SUBJECT: Engineering Review Comment
Mountain View Electric Association Inc. (MVEA)

Project Name: Rolling Hills Ranch North Filing 1 at Meridian Ranch – Final Plat
Project Number: SF2411

# ROLLING HILLS RANCH NORTH FILING NO. 1 AT MERIDIAN RANCH

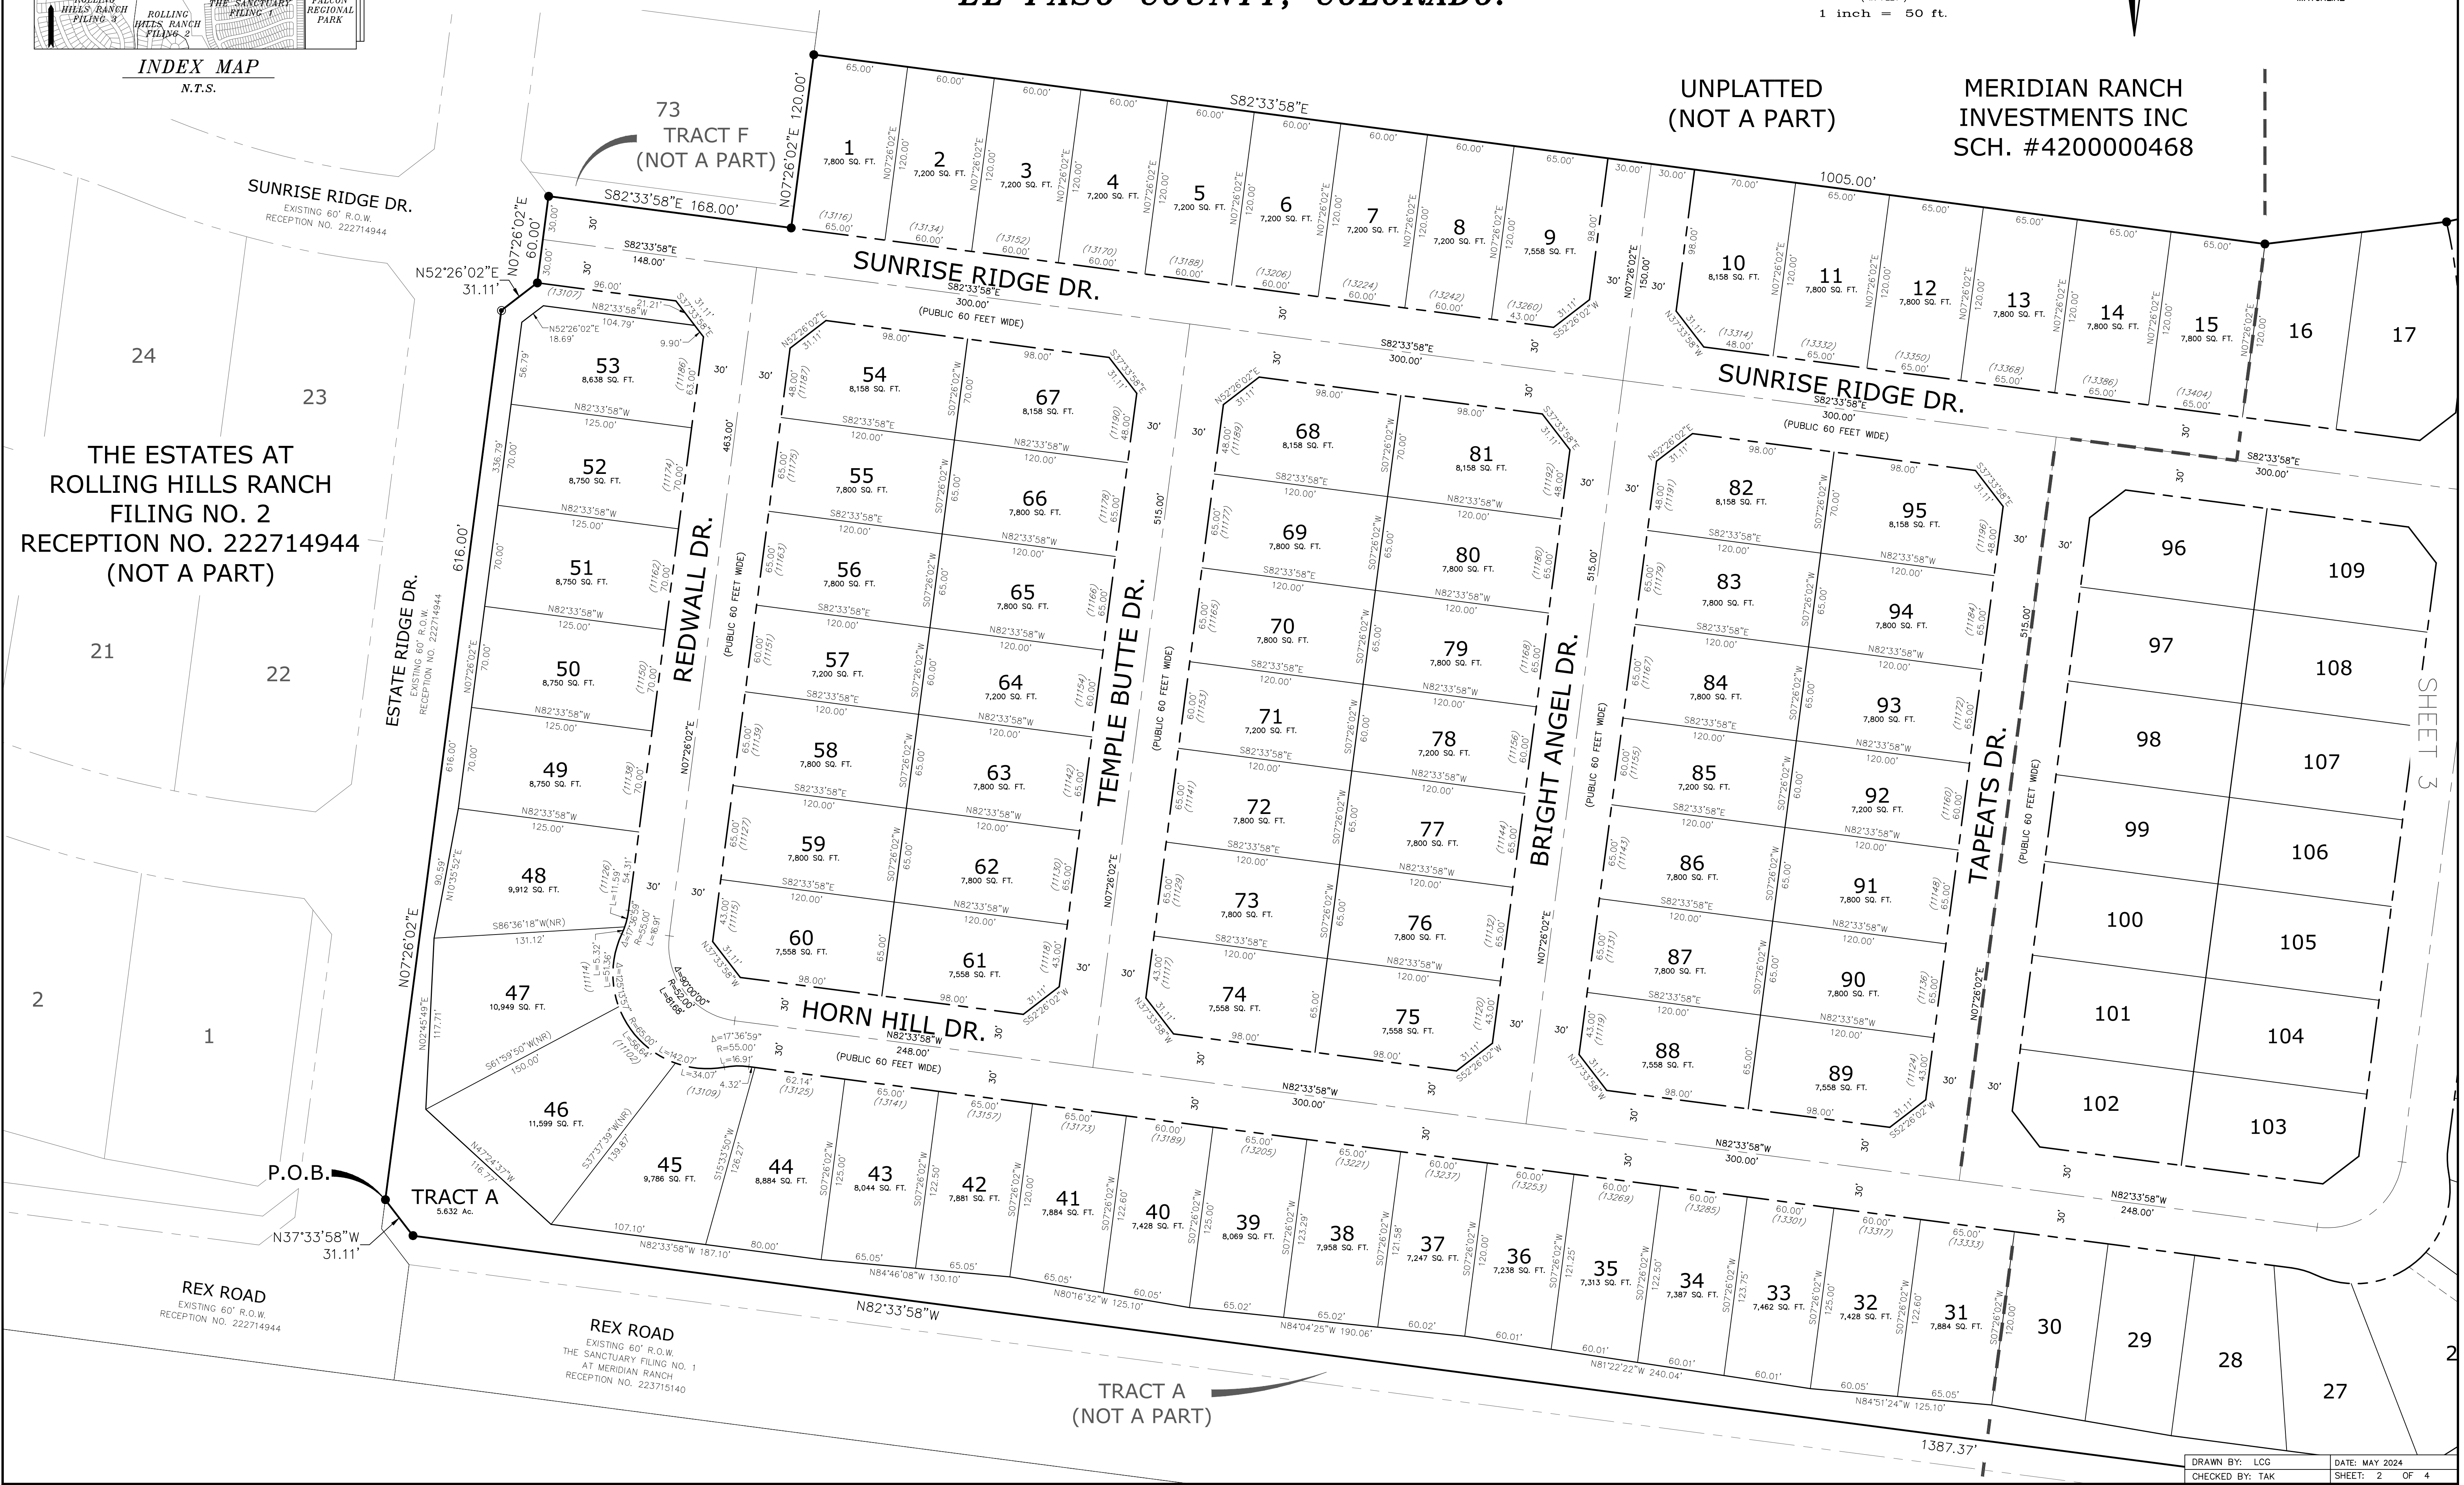
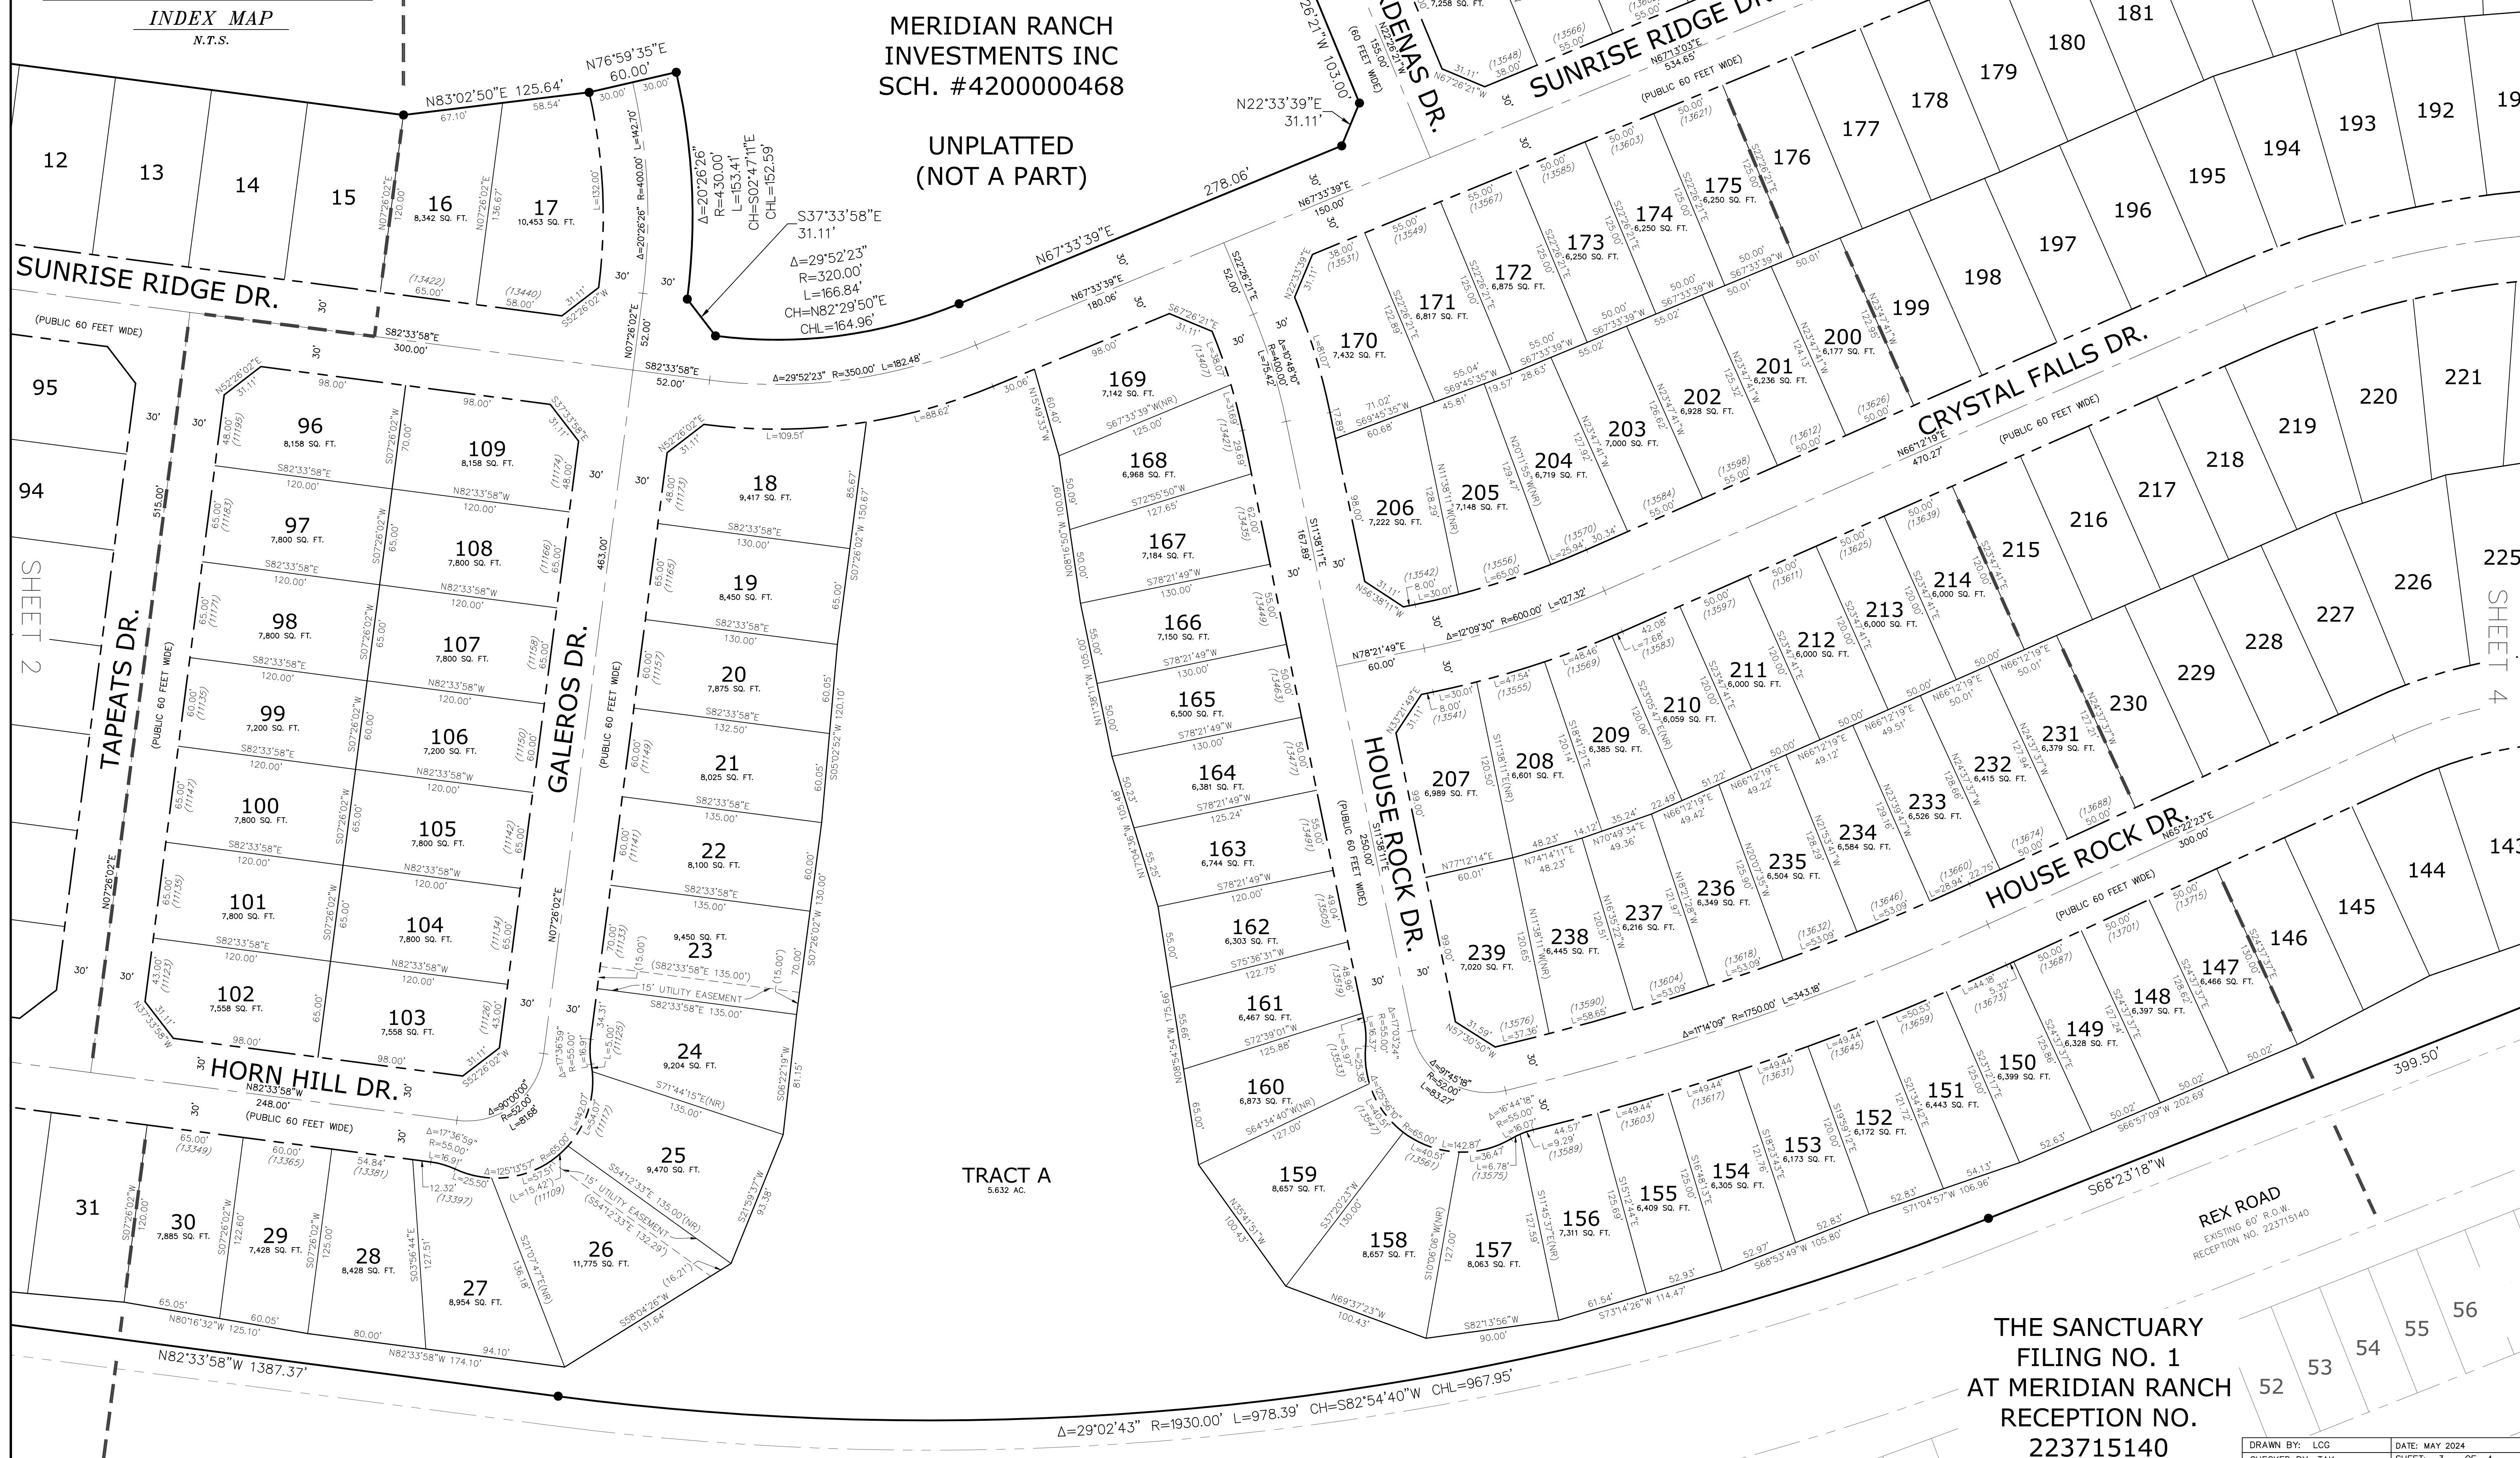
MVEA requests a ten (10) foot front lot utility easement, in addition to any public improvement easements, a five (5) foot side lot utility easement, and a seven and a half (7.5) foot rear lot utility easement along with a twenty (20) foot exterior utility easement on the plat and all tracts include easements. MVEA also requests the platting of MVEA's existing facilities with easements on the plat. Additional easements may be required.
